NSIP Reference Name / Code: Keadby Next Generation Power Station EN0110001

Natural England's Written Representations

These Written Representations are submitted in pursuance of rule 10(1) of the Infrastructure Planning (Examination Procedure) Rules 2010 ('ExPR') in relation to an application under the Planning Act 2008 for a Development Consent Order ('DCO') for **Keadby Next Generation Power Station Project** ('the Project') submitted by Keadby Next Generation Limited ('the Applicant') to the Secretary of State.

Plate 8B.2: Stack Height Determination (Hydrogen Firing)

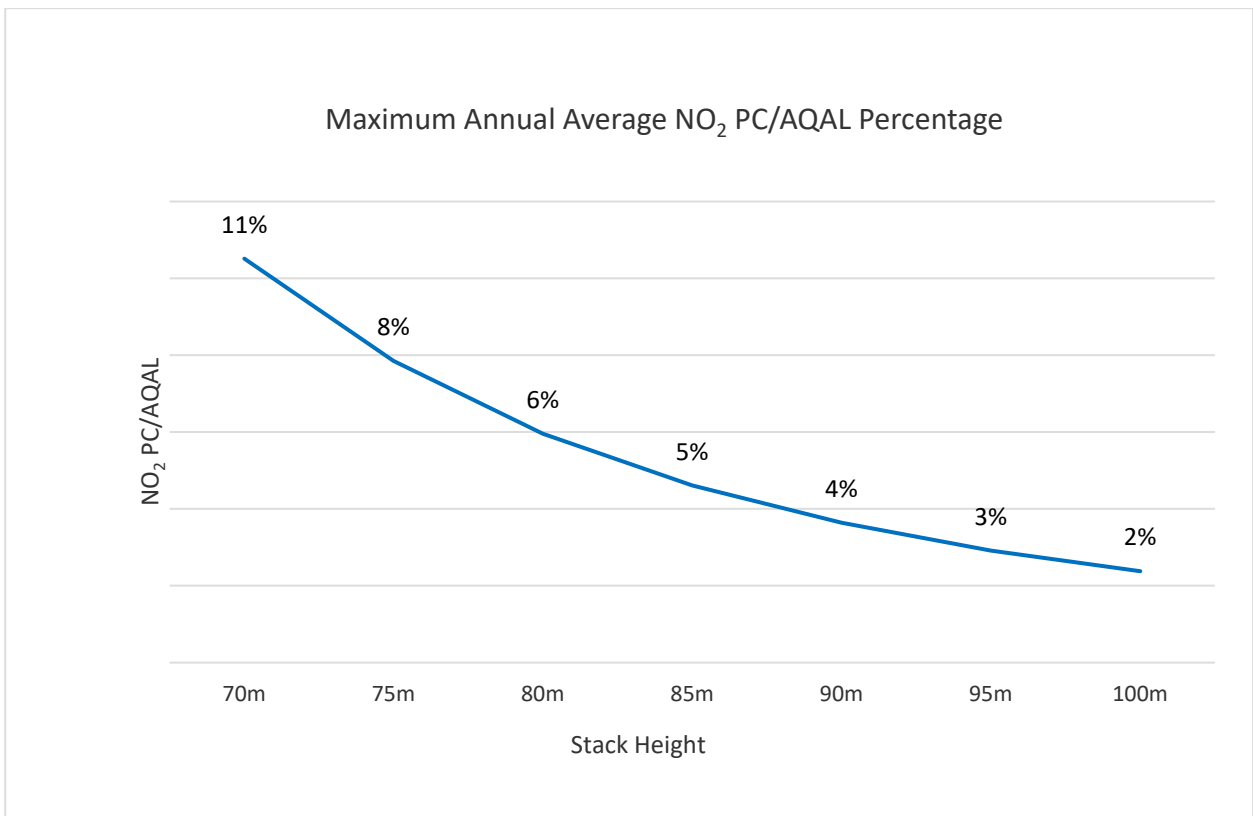
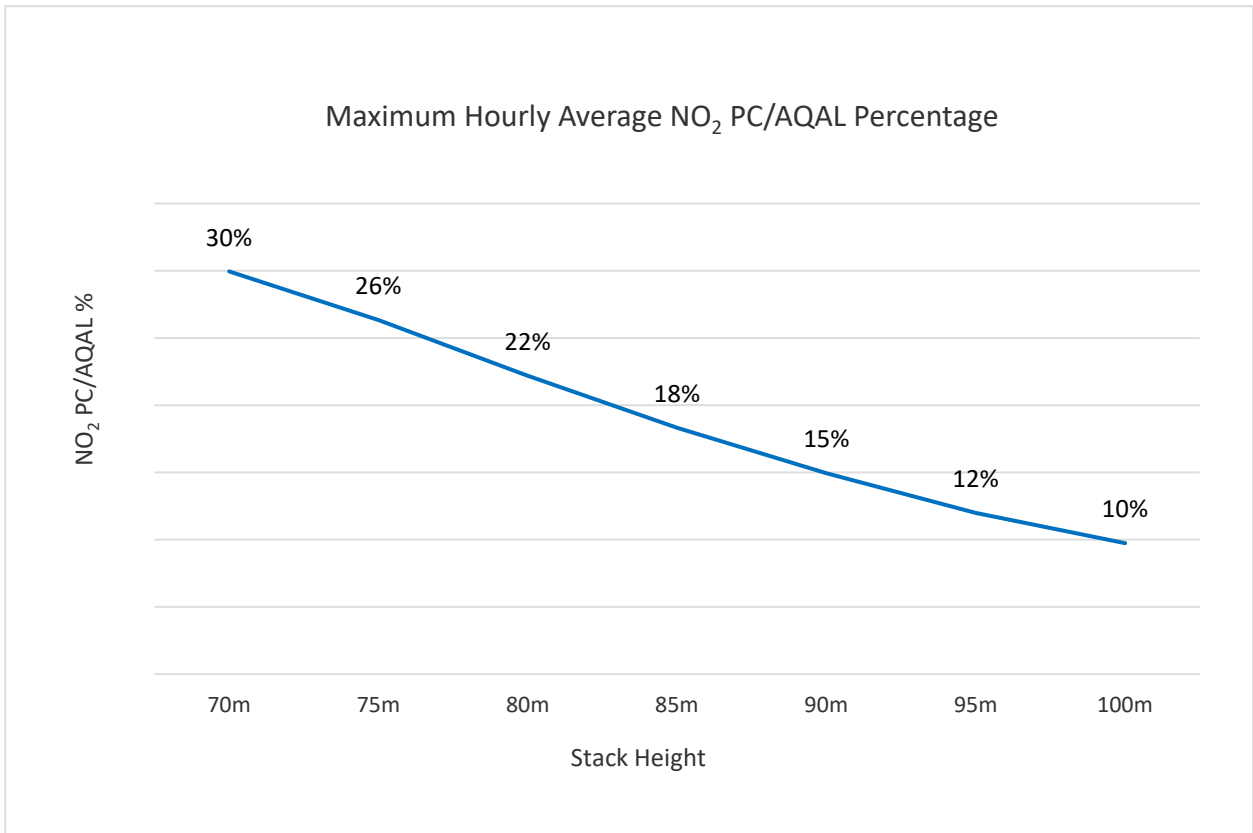
<p>NEs standard screening distance for general combustion processes is 500m, or 2km, depending on the nature of the source.</p> <p>The assessment of construction plant in the ES Section 8.6/ App8A does not refer to ecological receptors, but it is unclear whether this is because there were none in the relevant 200m, despite the red line boundary being adjacent to the Humber Estuary.</p> <p>The HRA (5.2.40) does confirm that there would be no construction activities requiring plant and NRMM within the 200m screening distance so there is no requirement to consider non-road machinery and plant. The closest construction activity to the European Sites is for the Proposed Canal Water Abstraction and this is located 600m west of the River Trent. A similar assessment should be made for SSSIs.</p>		
NE18	Air quality-Operational emissions	<p>Ch 8, App 8B, Ch 11 and HRA - The modelling used appears acceptable, though NE does not comment on modelling approach/ setup. Use of 5 years met data, and incorporation of buildings and topography in the model are acknowledged. The worst-case parameters are considered acceptable within the Rochdale envelope approach, and the sensitivity testing for stack height acknowledged.</p> <p>Confirmation should be sought that “improved dispersion” provided by a taller stack would not lead to potentially significant impacts at protected sites that are further from the development, where a shorter stack with lesser dispersion would result in lower pollutant levels (though the</p>	N/A	Amber

Figure 8B3.2 Trends in Nitrogen deposition Risby Warren

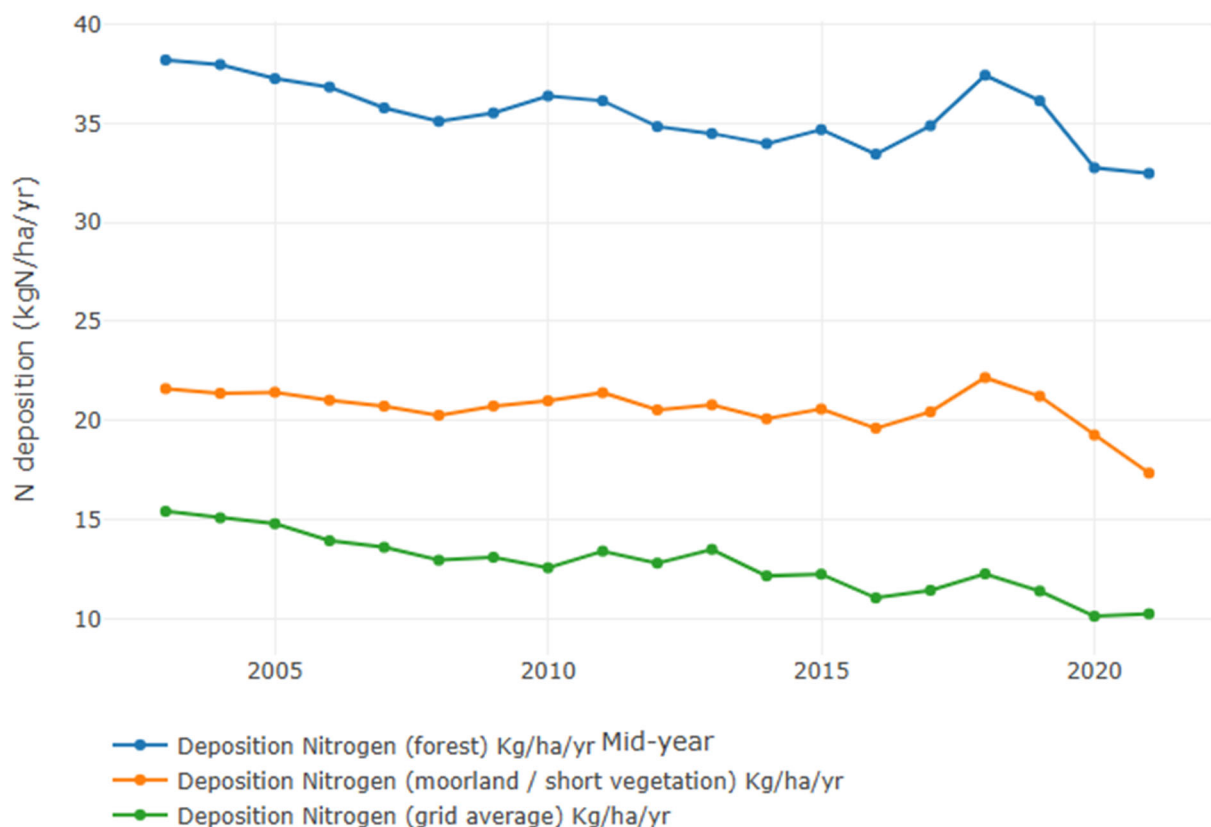
<p>on critical levels) which could result in >1% alone. In combination assessment and consideration of critical levels required before discounting harm at other sites.</p> <p>The conclusion in Ch 8 that the addition of 1% of the ammonia critical level at Risby Warren SSSI is “not significant” is not justified in ecological terms – especially as Risby warren SSSI is exceeding its ammonia critical level. This is not considered in Chapter 11 either (only the Ndep assessment is considered for this protected site).</p> <p>Although the background on APIS for the Humber Estuary is below 70% of the 3µg/m³ critical level (approx. 2µg/m³ which is 66% of the higher critical level – so the PEC is 67% - per Table 8B.14), given the uncertainty around in combination impacts, it would be precautionary to give more consideration to this pollutant at Humber Estuary.</p>		
NE20	Air Quality - Operational emissions – Nitrogen deposition and acid deposition results	<p>Ch 8, App 8B, Ch 11 and HRA - <i>Detailed assessment of Humber Estuary Ndep:</i> Consideration of the qualifying features at Humber Estuary is addressed in our response to earlier questions. the vegetation at OE1-5 is now assessed as upper saltmarsh (3.2% CL) and rich fen proxy (2.1% CL) which is considered appropriate. However, despite this we can agree there would be no AEOI from operational Ndep based on the assessment outlined in the revised HRA (eg para 7.4.8-7.4.17)</p> <p><i>Appendix 8A/B - Air Quality Assessments. These documents have not been updated so we re-iterate our previous comments for SSSI protected sites:</i></p>	N/A	Amber
